Agency Review Comments

Rocky Top, Site Development Plan

PPR1913

LDC Comment Responses 08.30.19
 David V. Hostetler - DVH
 dhostetler@ldc-inc.com
 (719) 528-6133

HIGHER GROUND DESIGNS, INC.
 LANDSCAPE ARCHITECTURE, PLANNING & IRRIGATION DESIGN
 5350 NORTH ACADEMY BLVD., STE. 207
 COLORADO SPRINGS, CO 80918
 Phone 719-477-7646
 Fax 719-268-1122

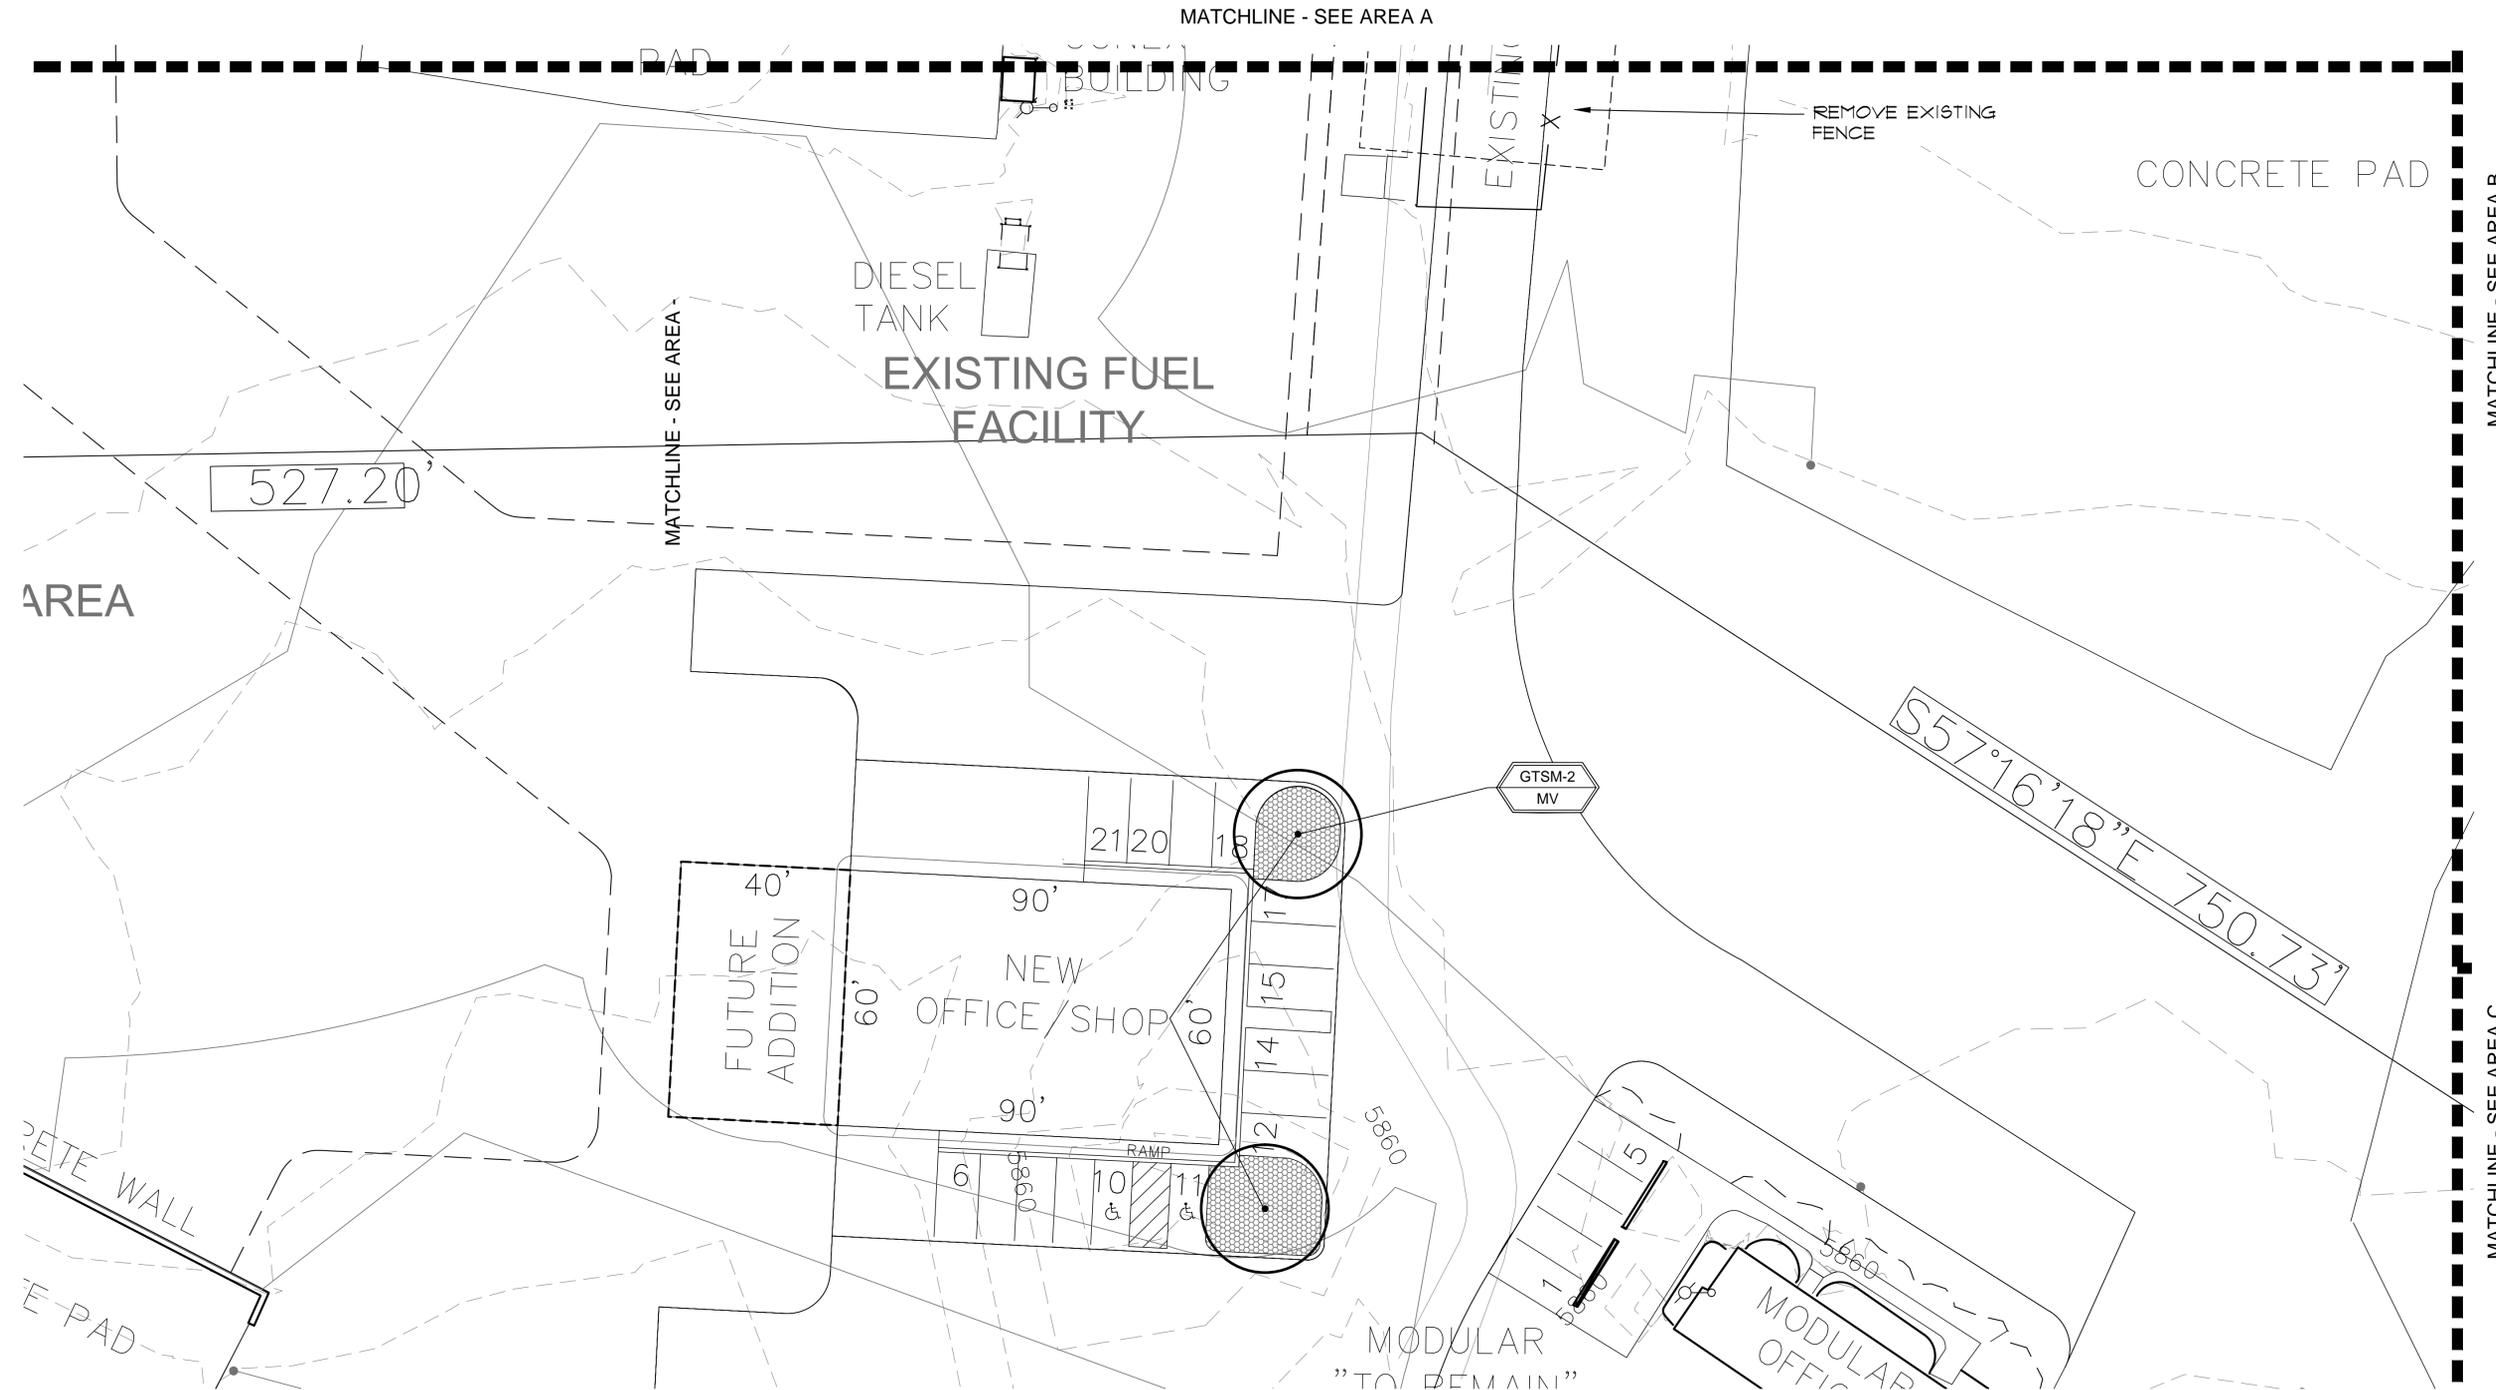
Please indicate that the existing trees are intended to stay.

Landscaping requirements pertain to the whole site. What are the required tree along Las Vegas and how many are being provided? Please provide information in the plant schedule. If the existing trees along Las Vegas are to remain, the plan must reference that information.

Section 6.2.2(C) Parking Lot Landscape Requirements. There are no trees indicated in this parking lot detail.

See revised Landscape Plan - DVH

ROCKY TOP RESOURCES

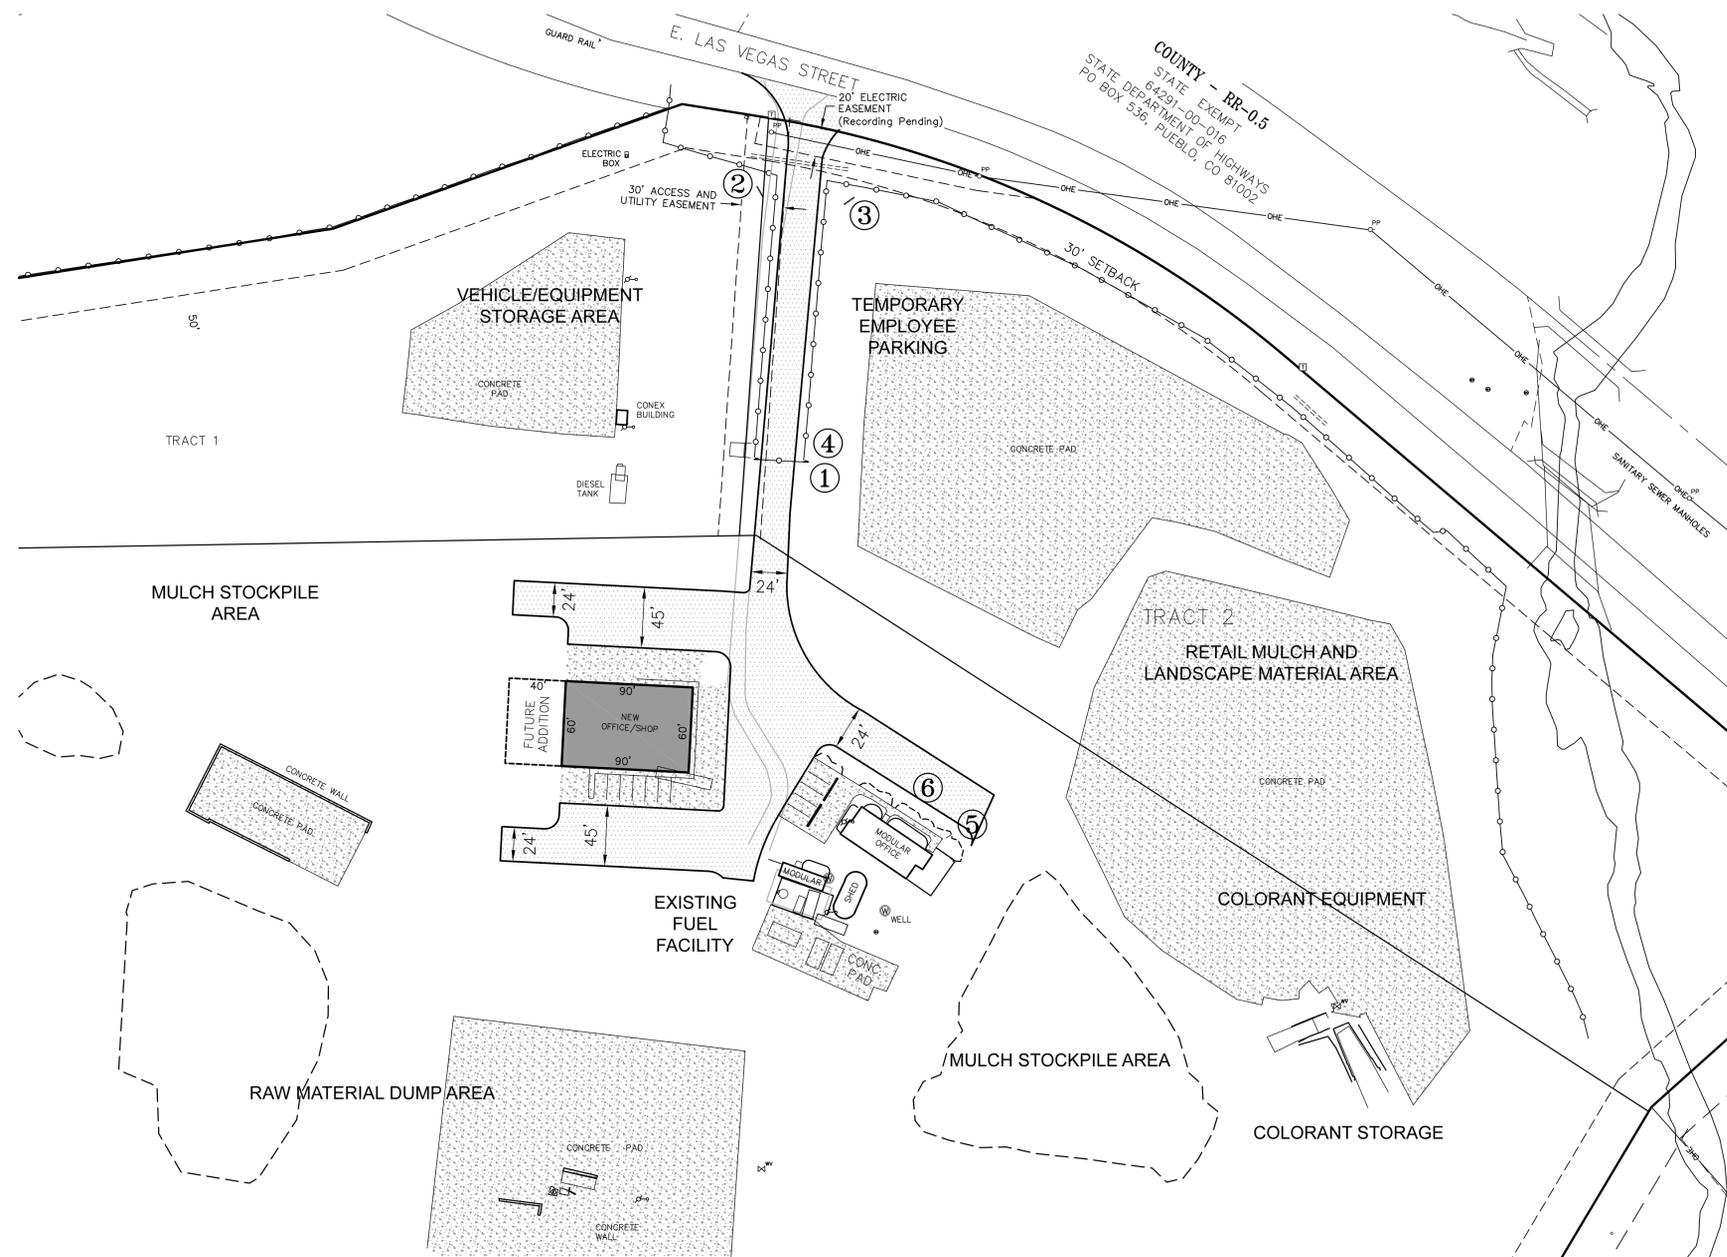
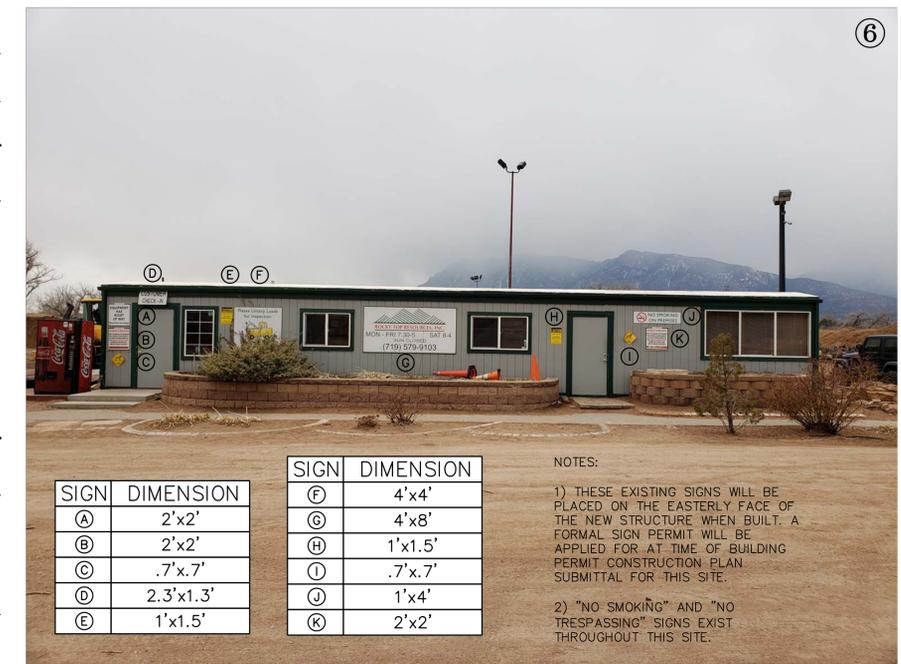
No sign permits currently exist for the site. All sign permits will be required to have a permit per the LDC requirements, directional signs are not required to be permitted. Please update sign plan to indicate which signs are pre-existing.

Plan updated. All signs existing. Sign permit will be applied for at time of building permit submittal - DVH
